Description: 3 bedroom house and detached garage (Renewal
of H06/0072/98)

Location: Lowgate
Gedney

Amendment: Access repositioned (dwg. no. 0440-01)

TOWN AND COUNTRY PLANNING ACT 1990
NOTICE OF ACCEPTANCE OF AMENDMENT

DATE	12500 1500	DATE	0440-01
TIME	12:30	TIME	JG.

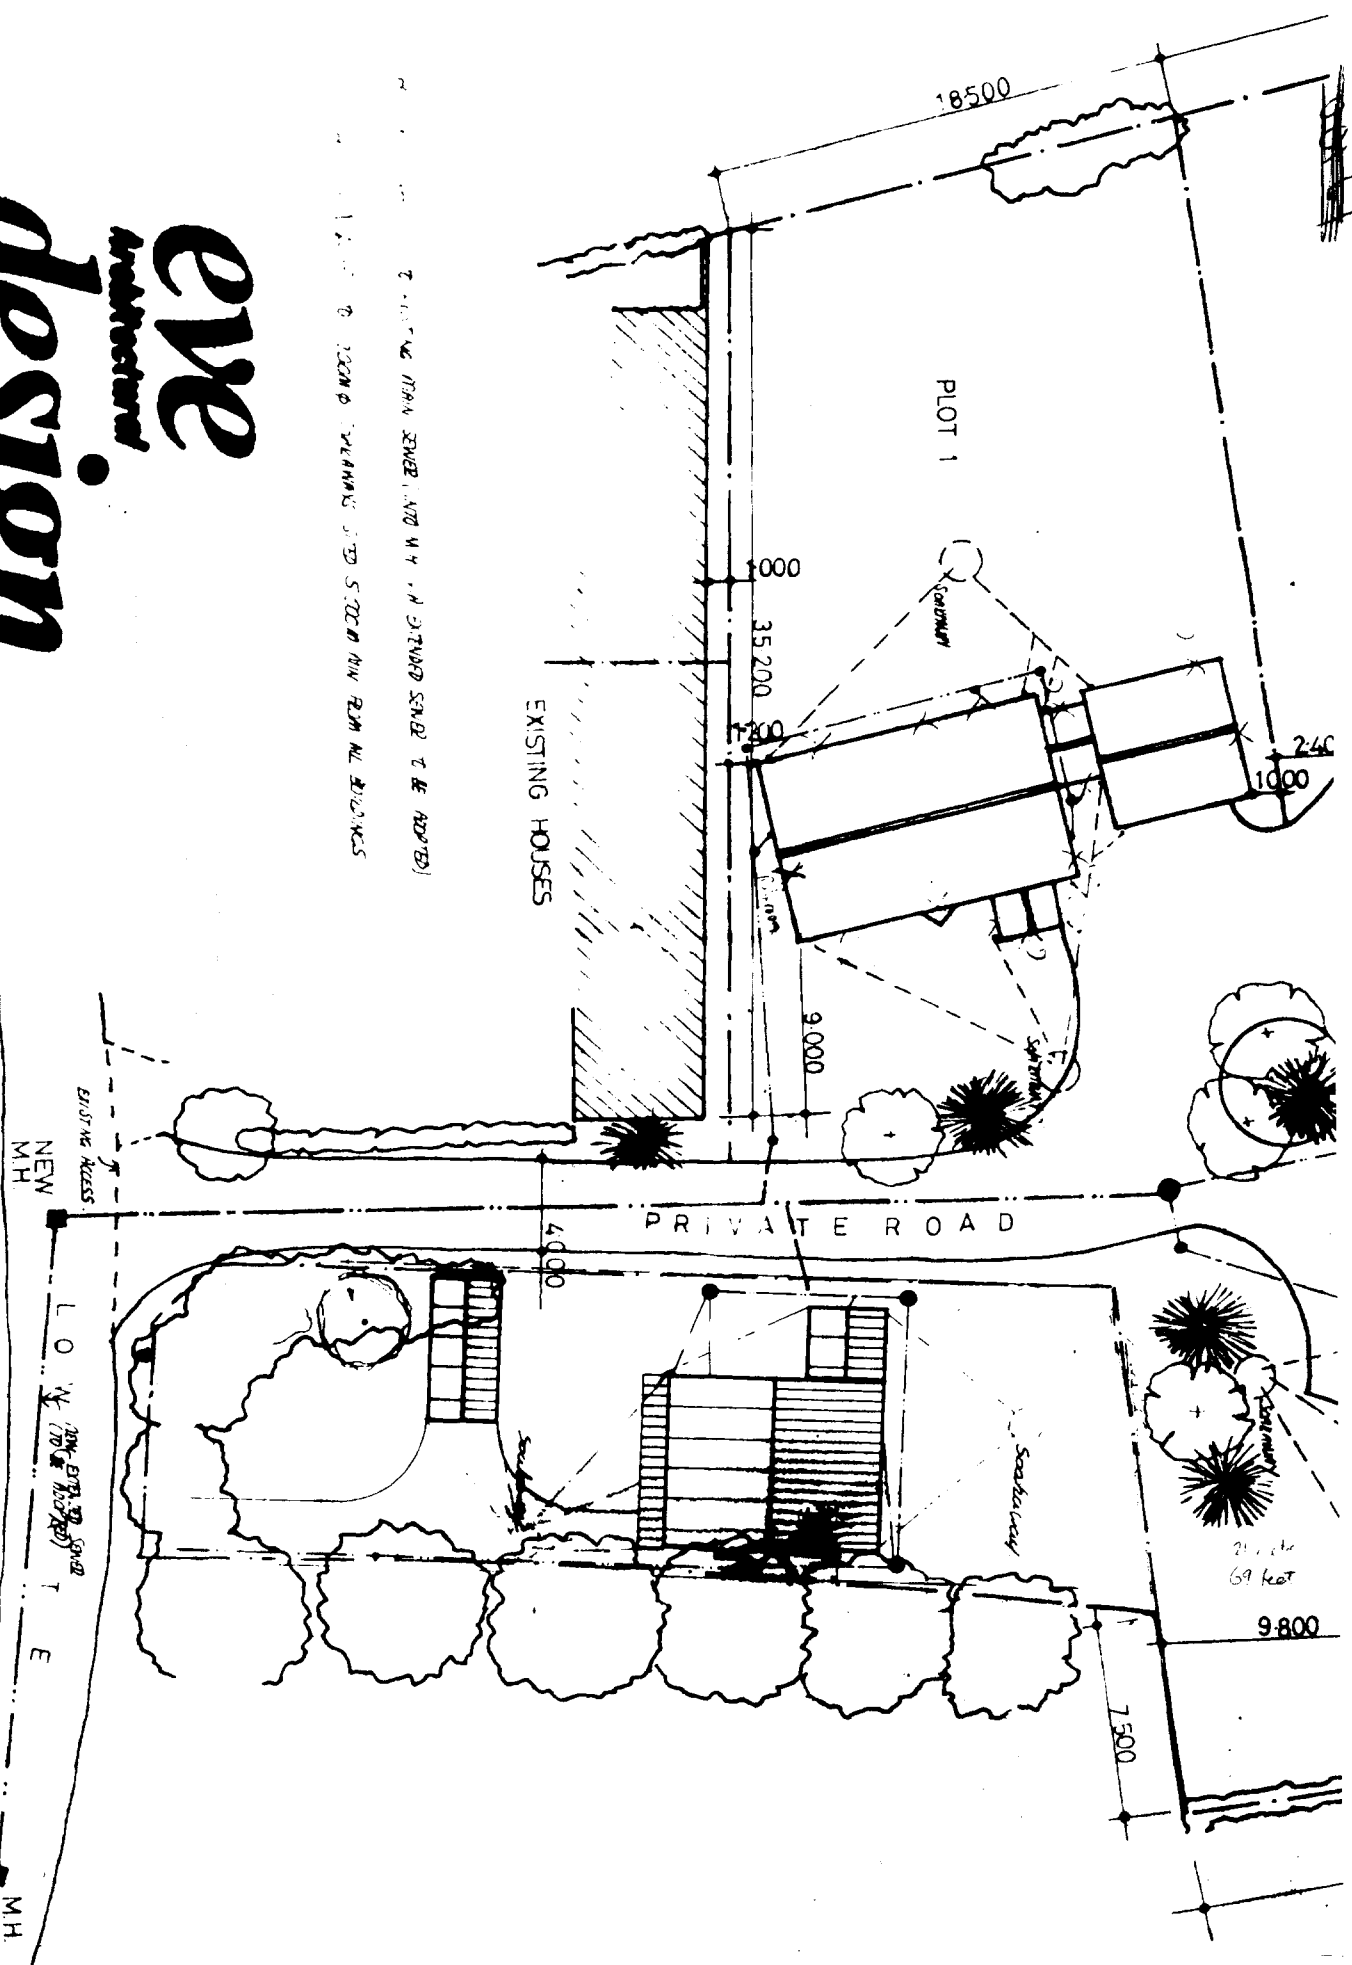
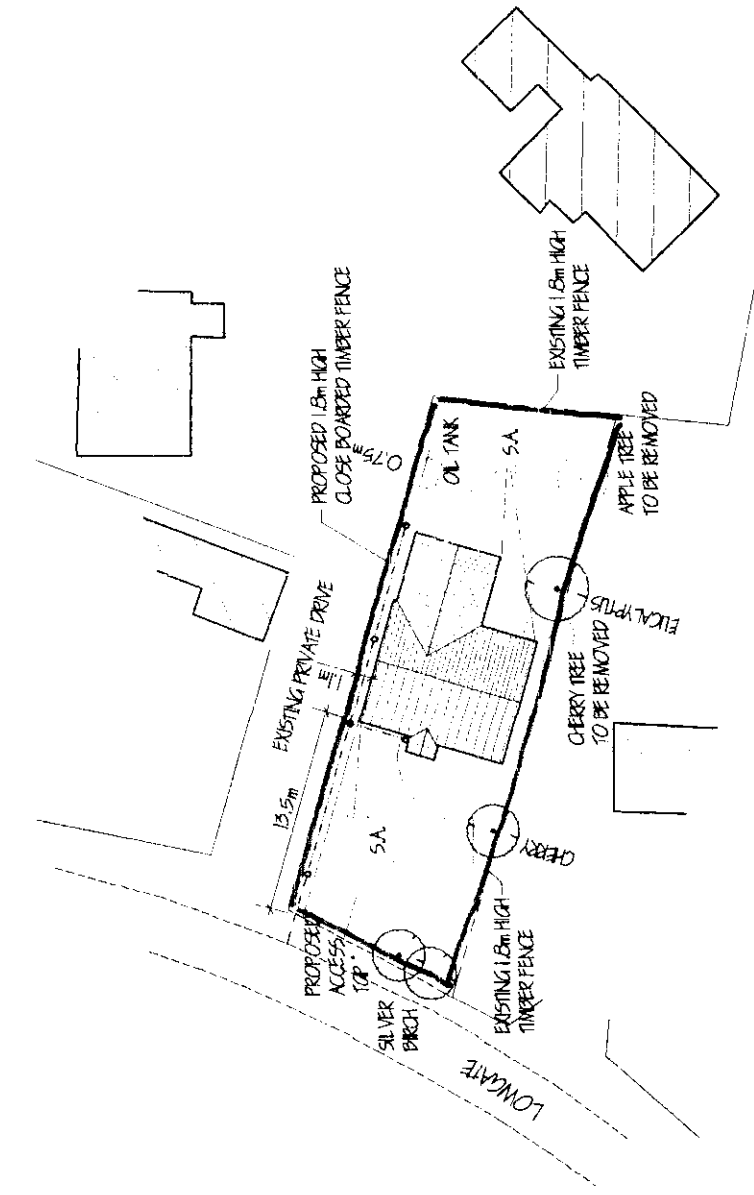
ACCESS REPOSITIONED

The amended details submitted in respect of the above proposal have now been considered and there are no objections to the amendment being implemented to the extent described above.
